TRANSPORT FOR LONDON - SILVERTOWN TUNNEL – DEVELOPMENT CONSENT ORDER APPLICATION

ISSUE SPECIFIC HEARING ON THE DEVELOPMENT CONSENT ORDER

19 JANUARY 2017

SUMMARY OF APPLICANT'S SUBMISSIONS

Figure 4-1: Process and principles for setting and varying the Statement of Charges

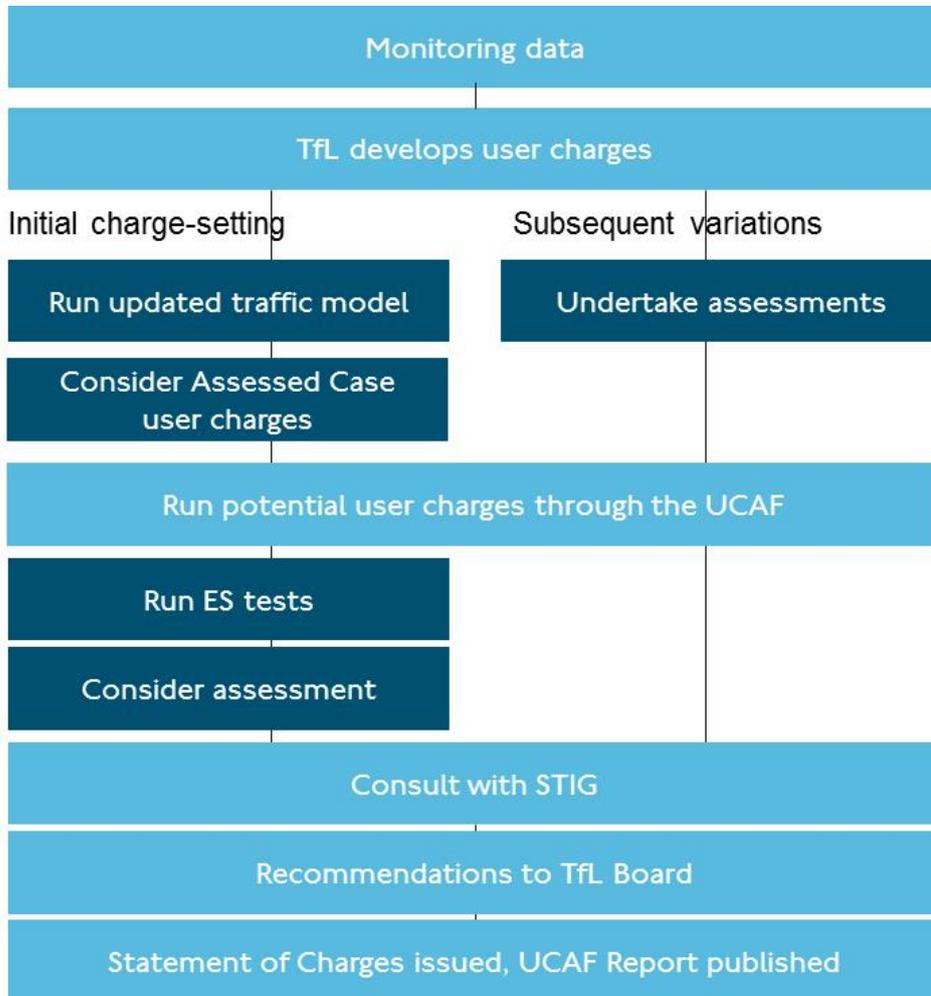
The Applicant will be asked to give examples of the circumstances under which the provisions of paragraph 4.5.1 of the revised Document 7.11 [REP1-123/4] might be applied as they are distinct from emergency situations that are provided for under paragraph 4.5.2. In addition, the Applicant will be asked to explain why variations to user charges would not be subject to a run of Environmental Statement (ES) tests and consideration of the assessment (as these steps are omitted in Figure 4.1 of that document) in order to give effect to Policy 9 of Document 7.11?

- The inclusion of paragraphs 4.5.1 and 4.5.2 in the Charging Policies and Procedures is intended to enable the Applicant to respond in a timely and appropriate way to events on the network or in London as a whole.

- Paragraph 4.5.1 applies to planned and foreseen events such as, for example, planned road works which could otherwise have a major impact on users or potential users of the Blackwall and Silvertown Tunnels. For the CC, the charge is occasionally suspended in response to the need for drivers to divert into the zone because of full or partial road closures outside it or on its boundary routes. There have been around half a dozen of these since the CC began in 2003 and it should be noted that the suspension is only partial, affecting only those journeys made as a result of this diversion; most trips continue to be charged. Because these diversions are known about in advance, the Applicant can make drivers aware in advance via its website, for example. Unlike the CC (which is a 19km² area of central London) the Blackwall and Silvertown Tunnels are distinct links, meaning that this type of diversion is likely to be unusual. It is possible that a closure of all alternative routes could lead to a suspension of the user charges, although this is an unlikely scenario.

- For the type of incident addressed by paragraph 4.5.2, the key difference is

<p>that in this case the incident is not known about in advance; a vehicle collision, for example. In the CC, there are around 10-20 incidents per year which lead to a partial suspension without prior notice of the charge, owing to the decision to re-route traffic around the incident via routes within the charging zone. With regard to the scheme, vehicle collisions within one of the tunnels could lead to diversions to the alternative tunnel (where a charge might still apply); collisions at other locations are not likely to lead to diversions to the Blackwall or Silvertown Tunnel, although this remains a possibility. Other events, such as a failure of all or part of the enforcement infrastructure, might also necessitate a change or suspension of the user charges without prior notice.</p> <ul style="list-style-type: none"> • The other circumstance for suspension without notice is an exceptional event which affects the entire city. This kind of event has led to a full suspension of the CC only twice, once for a terrorist attack and once in extreme weather. It is characteristic of such events that it is not possible to give examples that might affect the scheme. • In all cases, the ability to change or suspend the charge with or without notice enables TfL to better manage the overall impacts of the event on the network. It is envisaged that these powers would be used infrequently. • The Applicant does recognise however, that these paragraphs could be amended to clarify this. As such, amendments will be made to the revision of the Charging Policies and Procedures to be submitted at Deadline 4. <p>Mr Owen submitted that in respect of the ES tests, the User Charging Assessment Framework ("UCAF"), which is part of the Charging Policies and Procedures, provides for two separate scenarios – the setting of the initial charges and the variation of these charges in the future. Policy 9 makes clear that in varying the user charges in future, regard must be had to the likely impacts on the environment.</p> <p>John Rhodes of Quod, planning consultants to the Applicant, made the following further comments.</p> <p>It is difficult to replicate the ES tests in future due to the baseline changing and, as such, it</p>
